Post Approval – Consultation

Post Approval Consultation Record

From: [Jake Hausfeld](#)
To: [Tom Hemmett](#)
Cc: [Isaac Pinkerton](#)
Subject: RE: Road Safety Audit - Jordan Springs Public School
Date: Tuesday, 24 March 2020 3:20:15 PM
Attachments: [image001.png](#)
[image002.png](#)
[image003.jpg](#)
[image004.jpg](#)

Detailed design road safety audit

DRAWING TITLE  
CIVIL DOCUMENTATION  
CONSTRUCTION CERTIFICATE  
SITESWORKS AND STORMWATER  
MANAGEMENT PLAN - SHEET 01

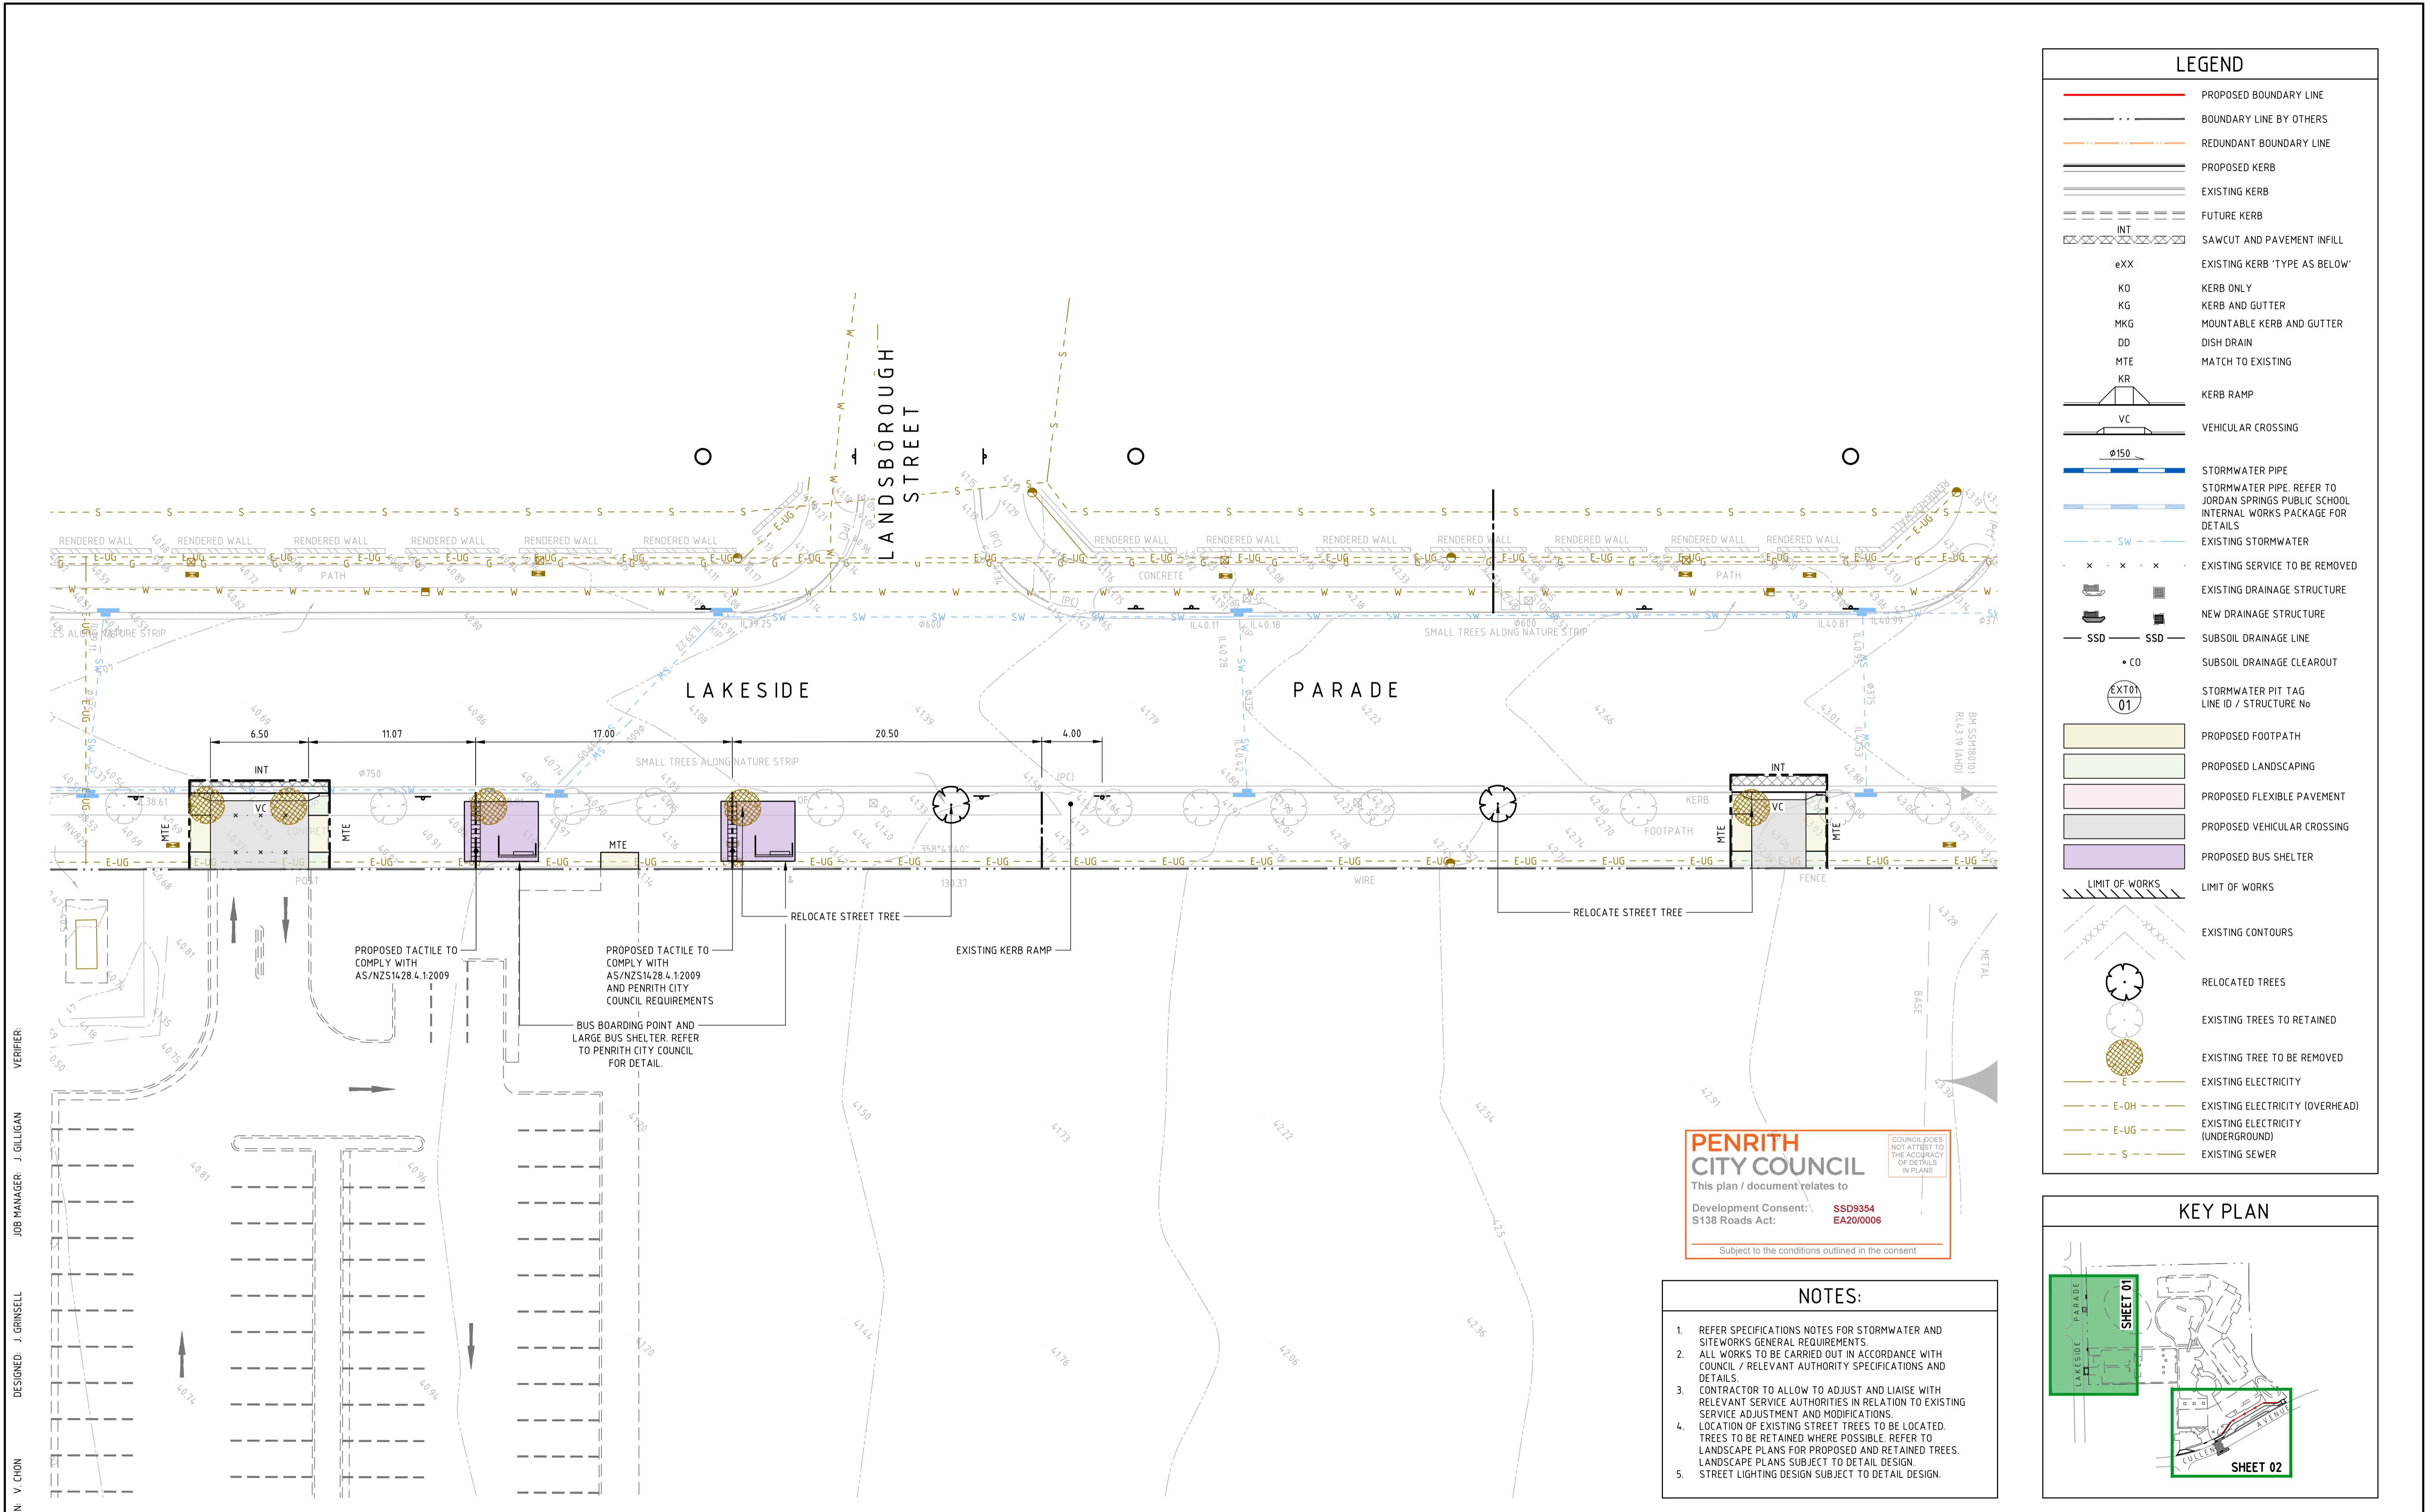
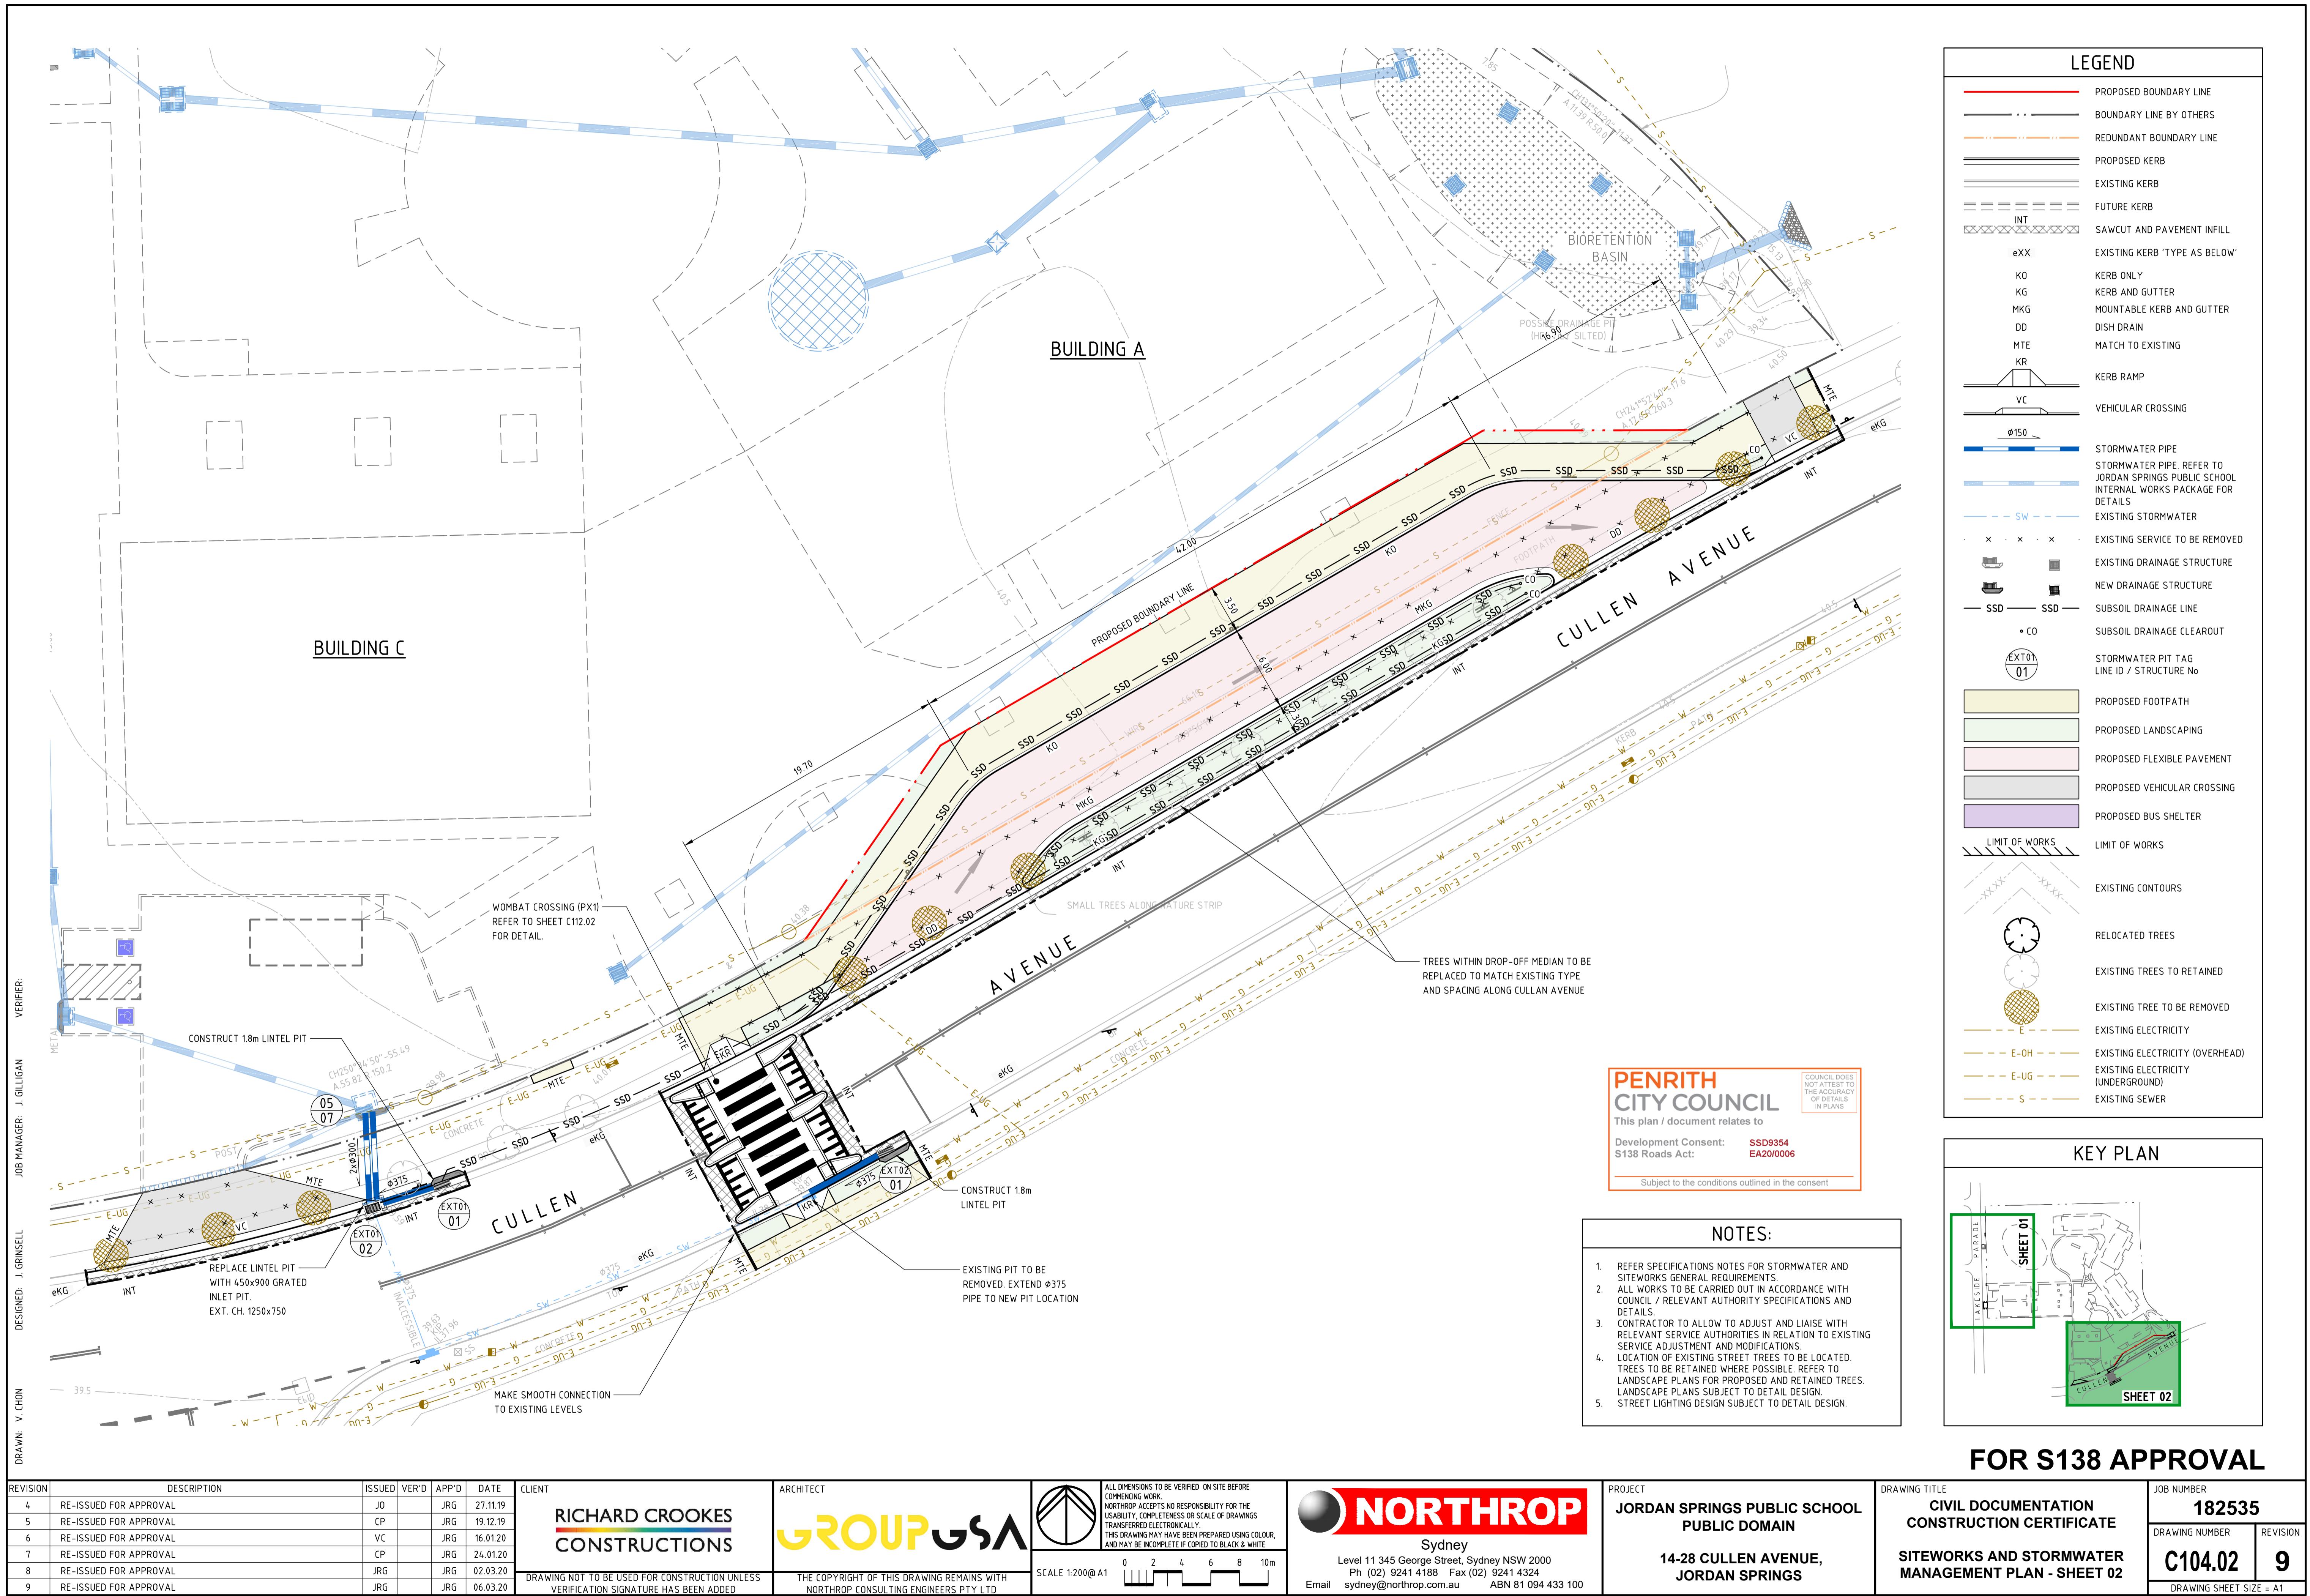
- The substation and associated easement adjoining the proposed staff parking from Lakeside Parade will not allow for the implementation of an egress path enabling students to avoid crossing the driveway fronting Lakeside Parade.
- The additional signage and line marking referenced in your response comment to item 4b is assumed to be that which has been shown on the approved signage and line marking plans. Any additional signage and line marking to this is subject to further review by Council.
- I agree with the recommendation in the report that a pick-up management strategy for the indented bay is developed. However I note that this is an operational requirement and outside the scope of the construction works.
